November 30, 2020

Re: Burger King-Juan Tabo
880 Juan Tabo NE
Traffic Circulation Layout
Architect's Stamp 11-23-2020 (K22-D035B)

Based upon the information provided in your submittal received 11-25-2020, the above referenced plan cannot be approved for Building Permit until the following comments are addressed:

### DO NOT ENTER SIGN

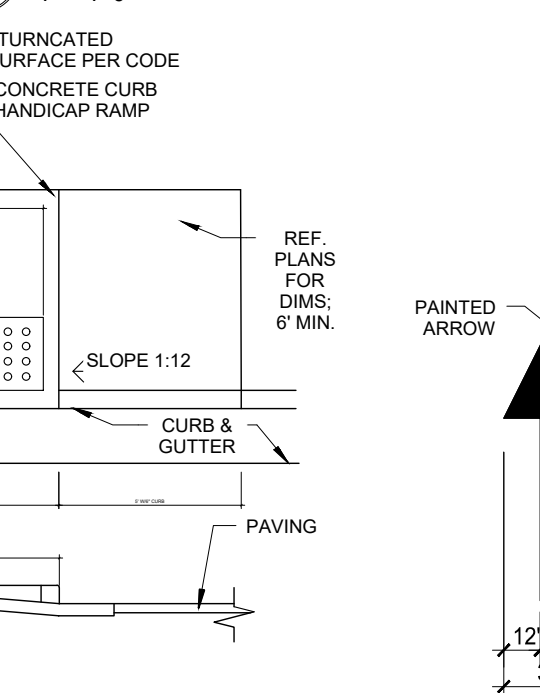
23. All one-way drives shall have "One Way" and "Do Not Enter" **pavement markings. Please show detail and location of posted signs, pavement markings, and striping.**

### MOTORCYCLE SIGNAGE

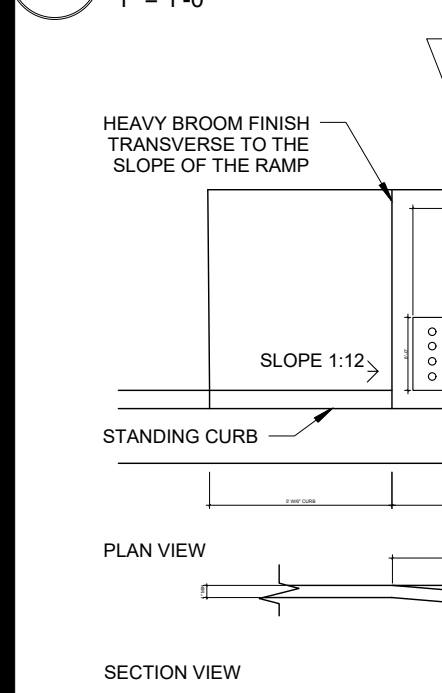
10. Proposed diagonal parking stalls: provide the angle being proposed to ensure that dimensions are appropriate size.
11. Motorcycle parking spaces shall be designated by its own conspicuously posted upright sign, either free-standing or wall mounted per the zoning code. **Label pavement MC.**

### BIKE RACK DETAIL

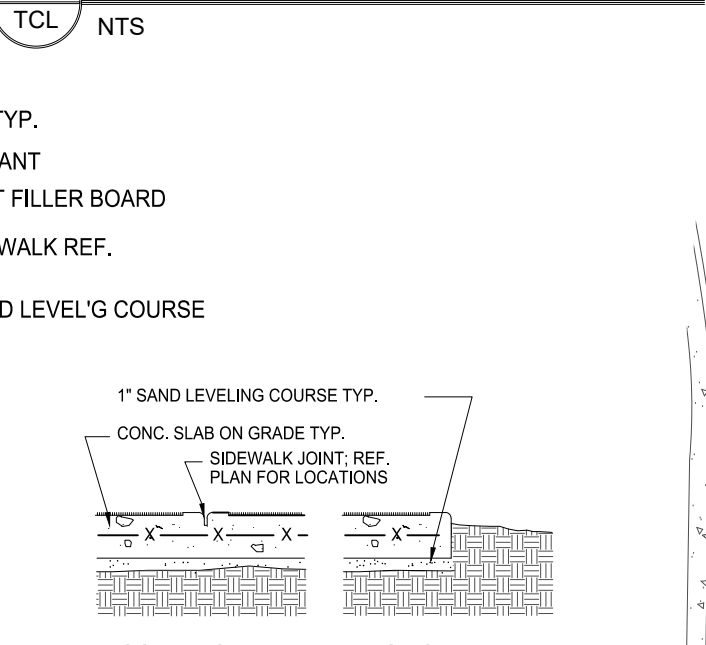
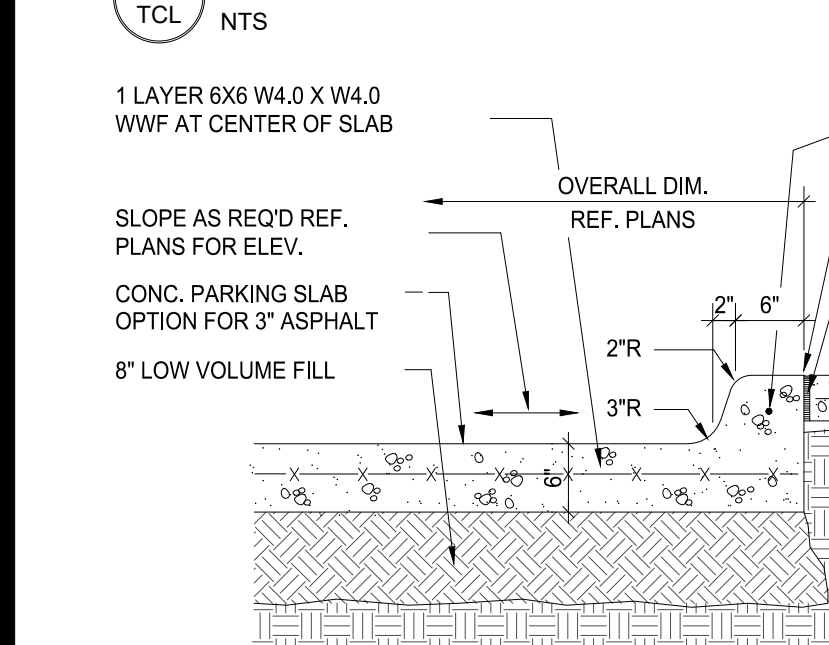
12. All bicycle racks shall be designed according to the following guidelines:
 - a. The rack shall be a minimum 30 inches tall and 18 inches wide.
 - b. The bicycle frame shall be supported horizontally at two or more places. Comb/toaster racks are not allowed.

- c. The rack shall be designed to support the bicycle in an upright position. See the IDO for additional information.
 - d. The rack allows varying bicycle frame sizes and styles to be attached.

- e. The user is not required to lift the bicycle onto the bicycle rack.
 - f. Each bicycle parking space is accessible without moving another bicycle.

13. Bicycle racks shall be sturdy and anchored to a concrete pad.
14. A 1-foot clear zone around the bicycle parking stall shall be provided.
15. Bicycle parking spaces shall be at least 6 feet long and 2 feet wide.

**A1.1**

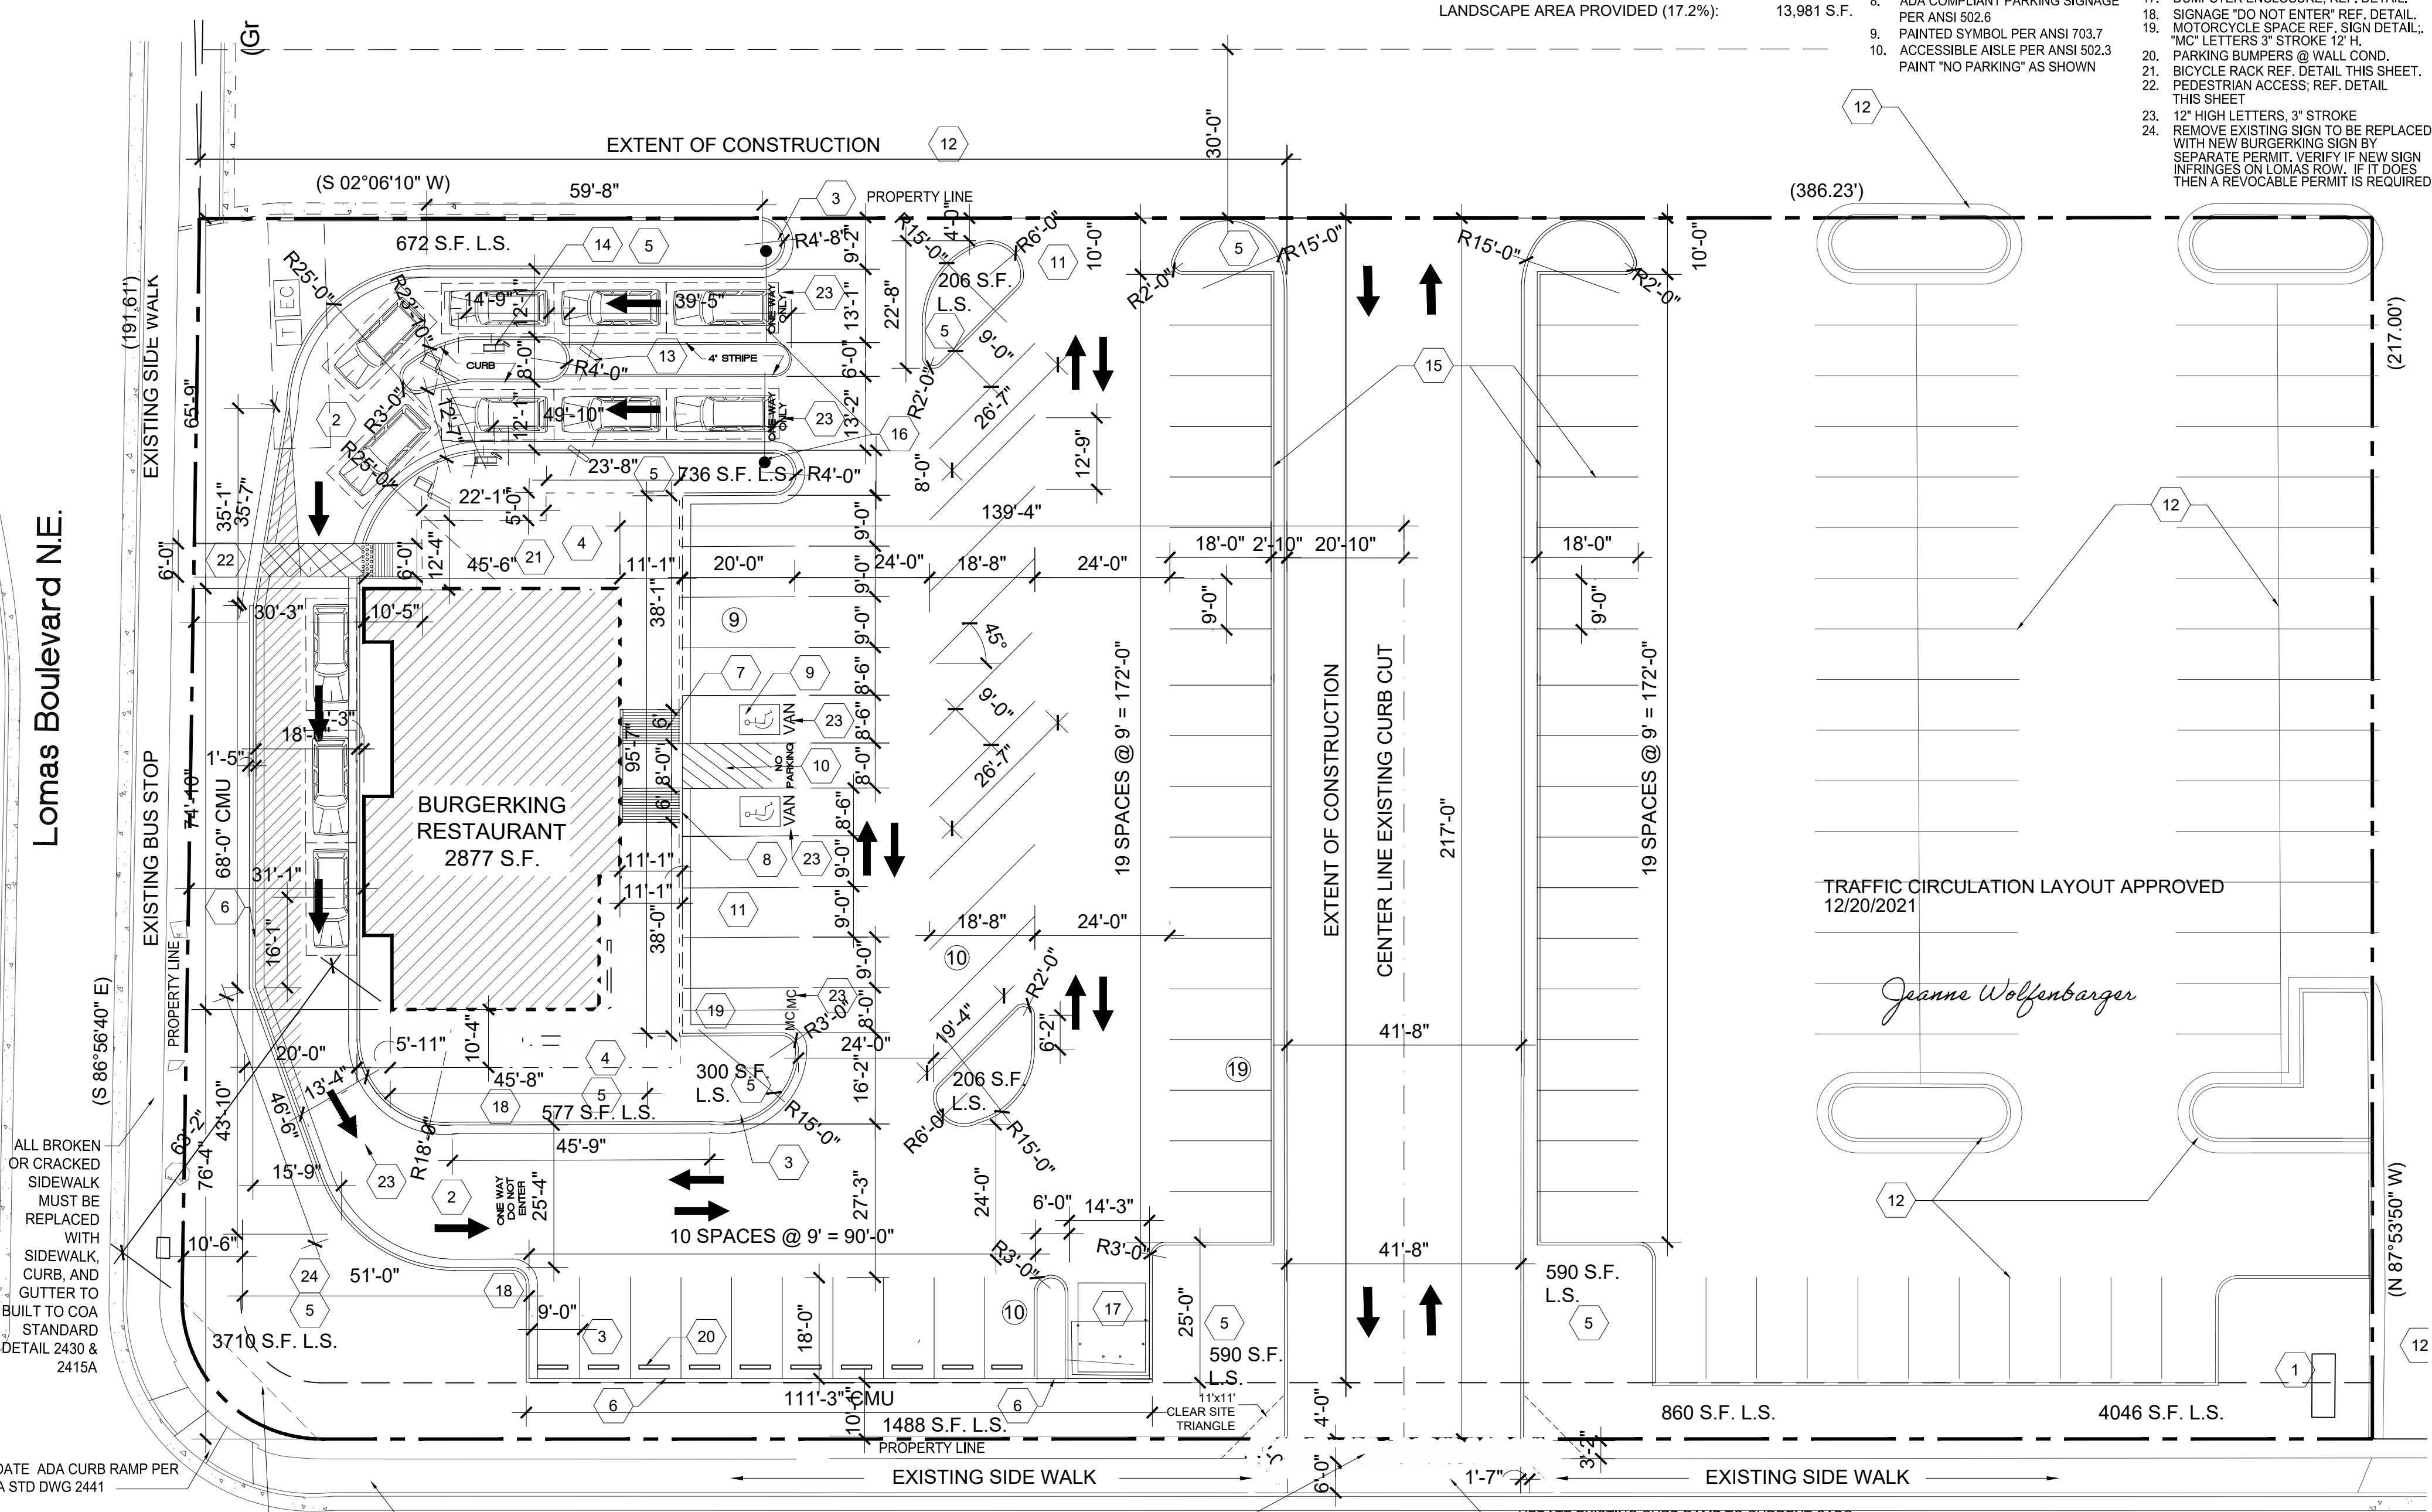
1. The listed number of parking spaces required by the zoning code as well as the proposed number of parking spaces including bicycle and motorcycle parking. All proposed required calculations need to be discussed with Zoning.
2. Clarify the extents of the current phase. Provide a phasing plan since nothing is being done on the southern portion of parking lot.
3. Identify all existing access easements and rights of way width dimensions.
4. Identify the right of way width, medians, curb cuts, and street widths on Lomas Blvd and Juan Tabo NE..
5. Grades and slopes in the parking area and/or the ADA accessible parking areas appear to be too large. Please provide more detail.
6. Please list the width and length for all existing and proposed parking spaces. Some dimensions are not shown.
7. The minimum parking stall dimensions are:

8. The ADA accessible spaces access aisle: The aisle needs to be 2% in all directions. Please verify this condition.

9. ADA curb ramps must be updated to current standards and have truncated domes installed at all public ROW. Includes drivepad off Juan Tabo needs to be current/updated ADA.

16. List radii for all curves shown; for passenger vehicles. **Radius for delivery trucks, fire trucks, etc. is 25 ft. or larger.**
17. Per DPM, a 6 ft. wide ADA accessible pedestrian pathway is required from the ADA parking stall access aisles to the building entrances. Please clearly show this pathway and provide details.

18. Keyed Note 7: The slope shall be 12:1 max for the transition leg and 2% landing. Please adjust note to reflect.
19. All referenced keyed notes will need a detail provided.

20. ADA accessible pedestrian pathway should not be placed behind parking space or adjacent to a vehicular way. Vehicle and pedestrian/wheel chair conflicts should be avoided as much as possible.

21. Parking areas shall have barriers to prevent vehicles from extending over public sidewalk, public right-of-way, or abutting lots.
22. It is not apparent what type of pavement surface is being proposed for the patch work. Please provide pavement design.

24. The minimum drive through lane width is 12 feet with a 25 foot minimum radius **(inside edge) for all turns. (A 18 foot radius** can be used with an increase in lane width to 14 feet).

25. Please provide a sight distance exhibit
26. Show the clear sight triangle and add the following note to the plan:
"Landscaping and signage will not interfere with clear sight requirements. Therefore, signs, walls, trees, and shrubbery between 3 and 8 feet tall (as measured from the gutter pan) will not be acceptable in the clear sight triangle.
